Subject: Y/76/21/DOC Condition 5 Flint Walls

Development	YAPTON		
Location	NORTH_END_ROAD_YAPTON		
Marketing Name	-		
Drawing Title	FLINT_WALL		
Drawing Number	783-DET-002		
Revision	-	Scale @ A1	1:10_ & 1:200
Drawn By	SK	Date Started	24.05.2021
Checked by		Date

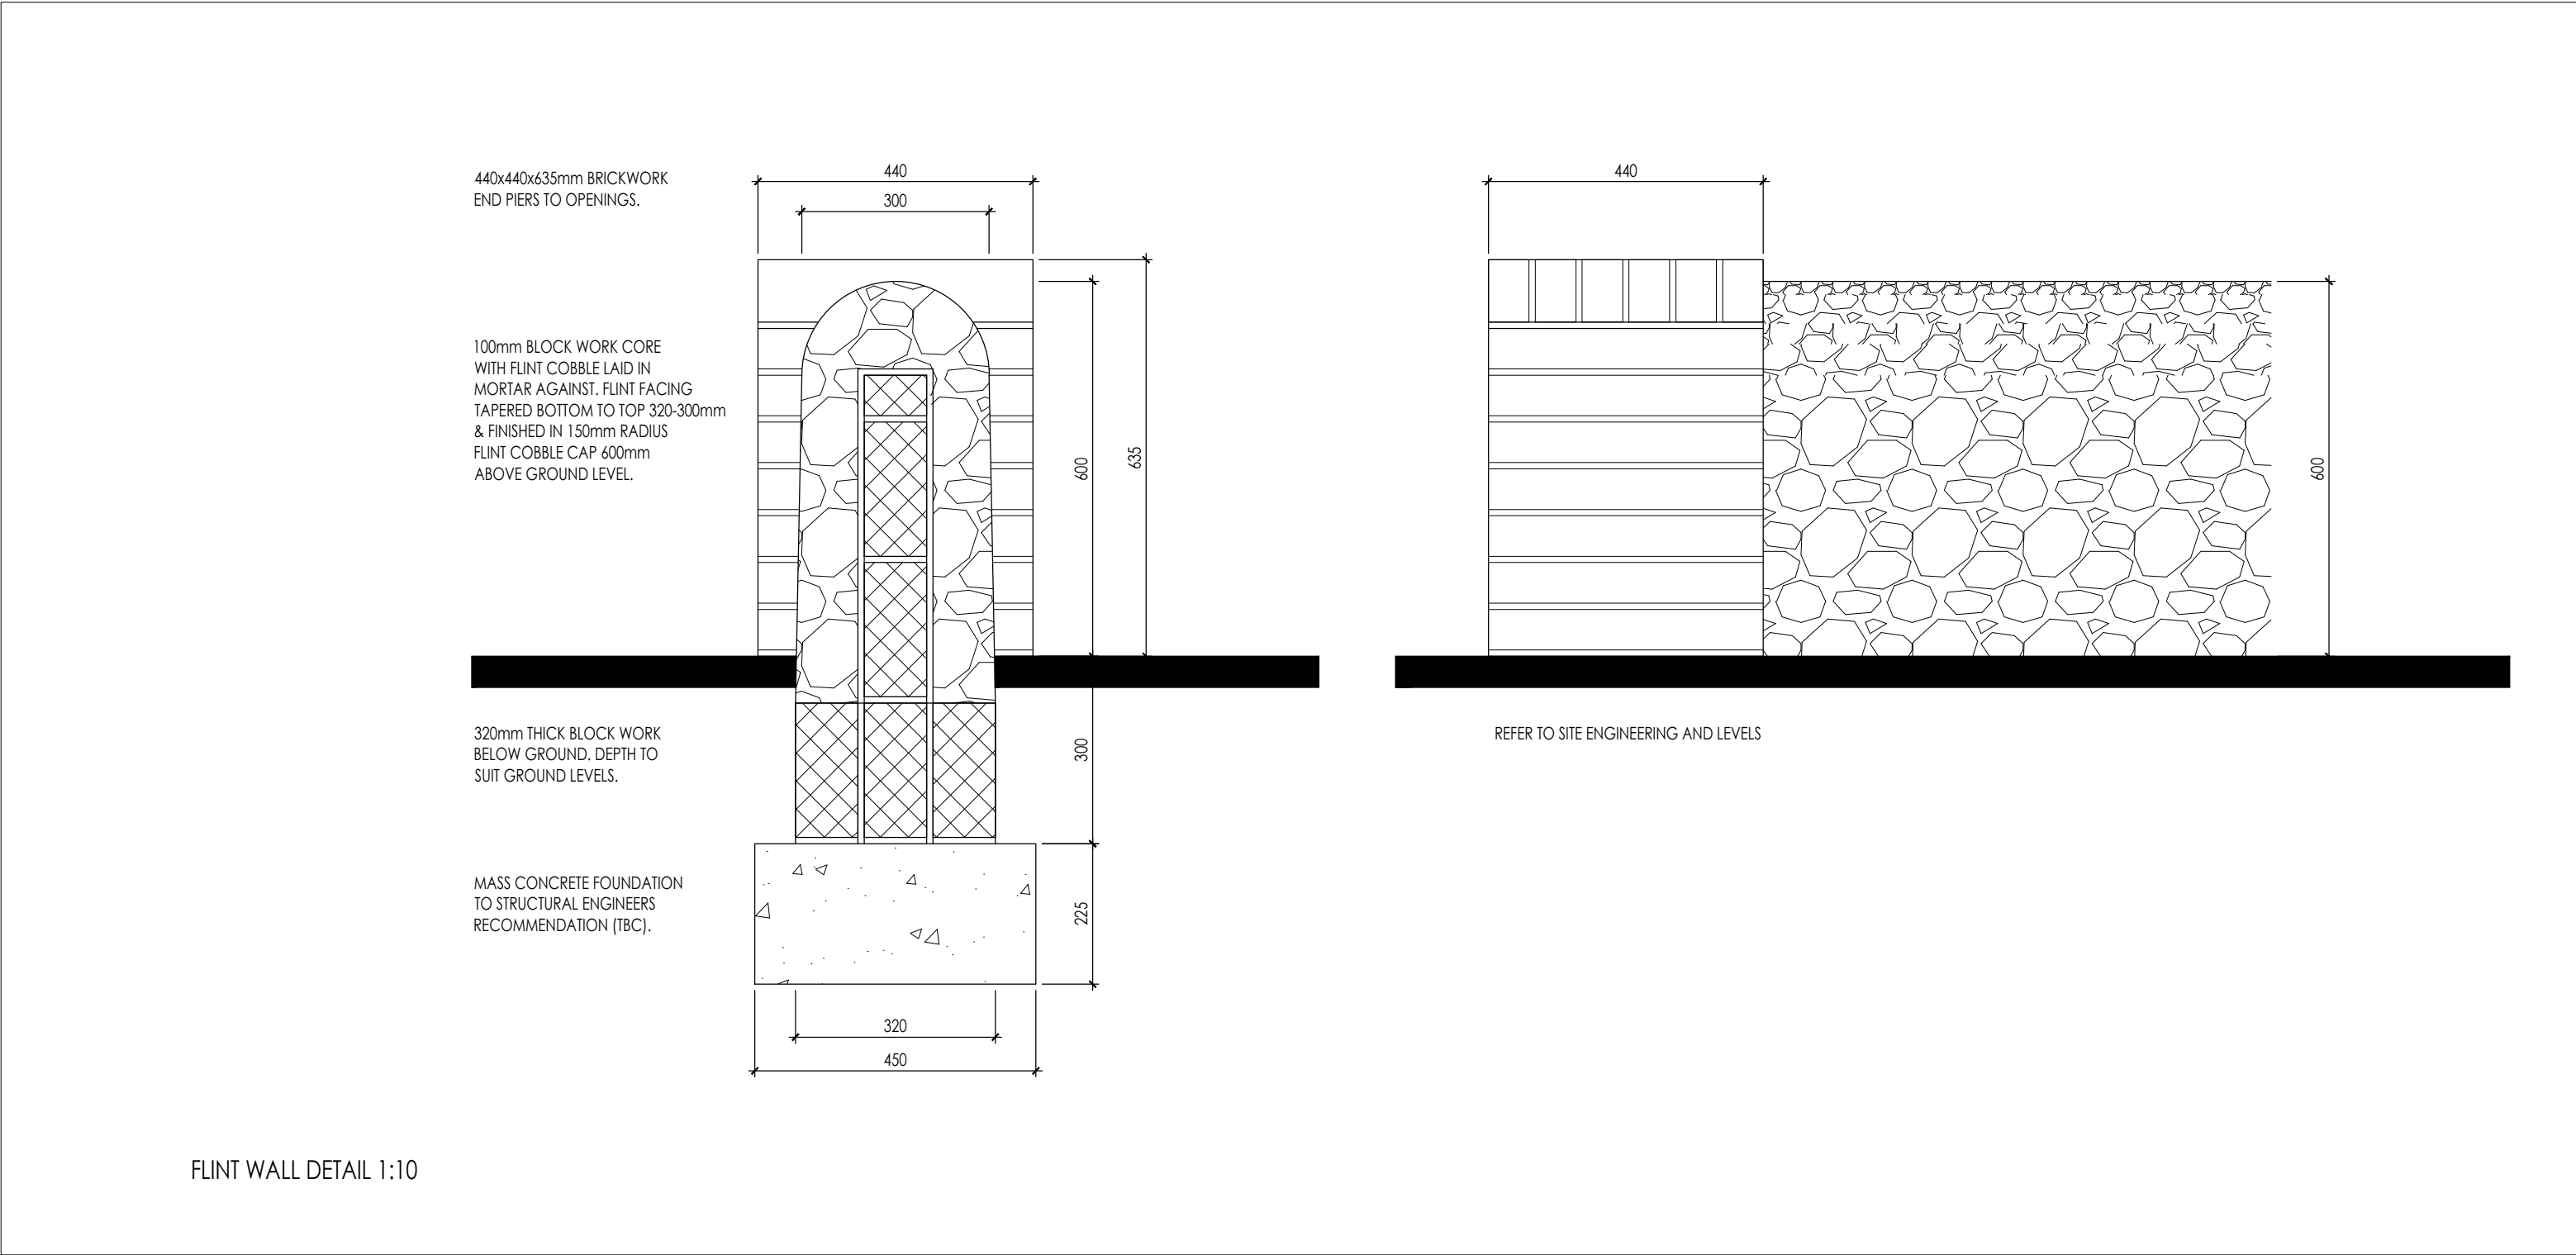
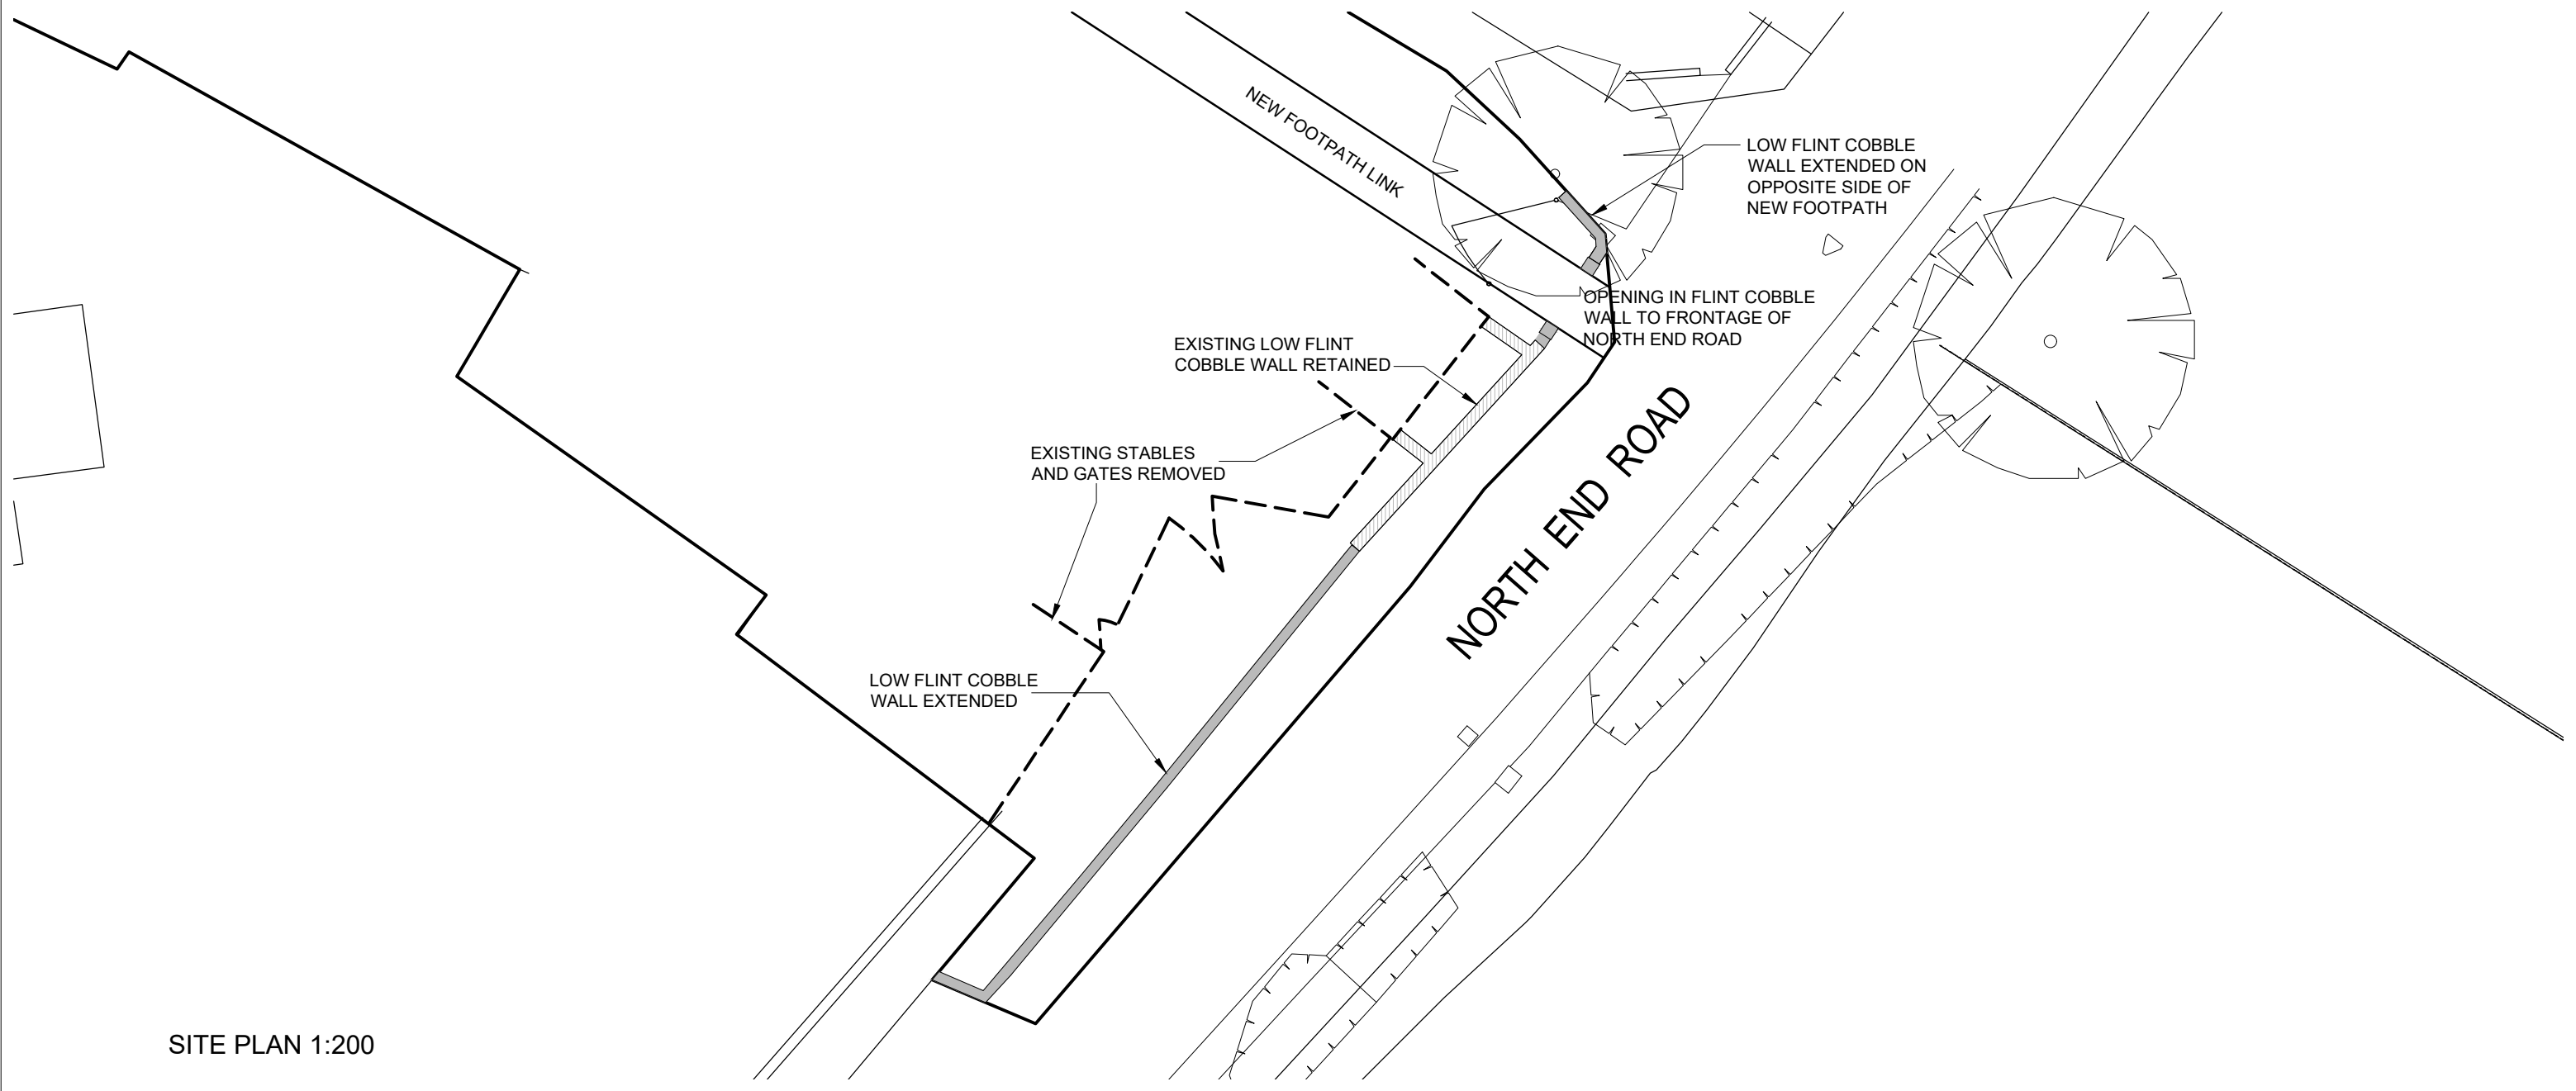
"The design of the flint wall seems to be generally acceptable and appears to replicate the existing wall. However, it is not clear how the southern end of the new section of flint walling will connect back to the neighbouring walling. At present, it looks as though the new section of wall terminates in front of, but not connected to, the neighbouring flint wall. Is this correct. If so, it will leave a section without any walling. Please can this be clarified."
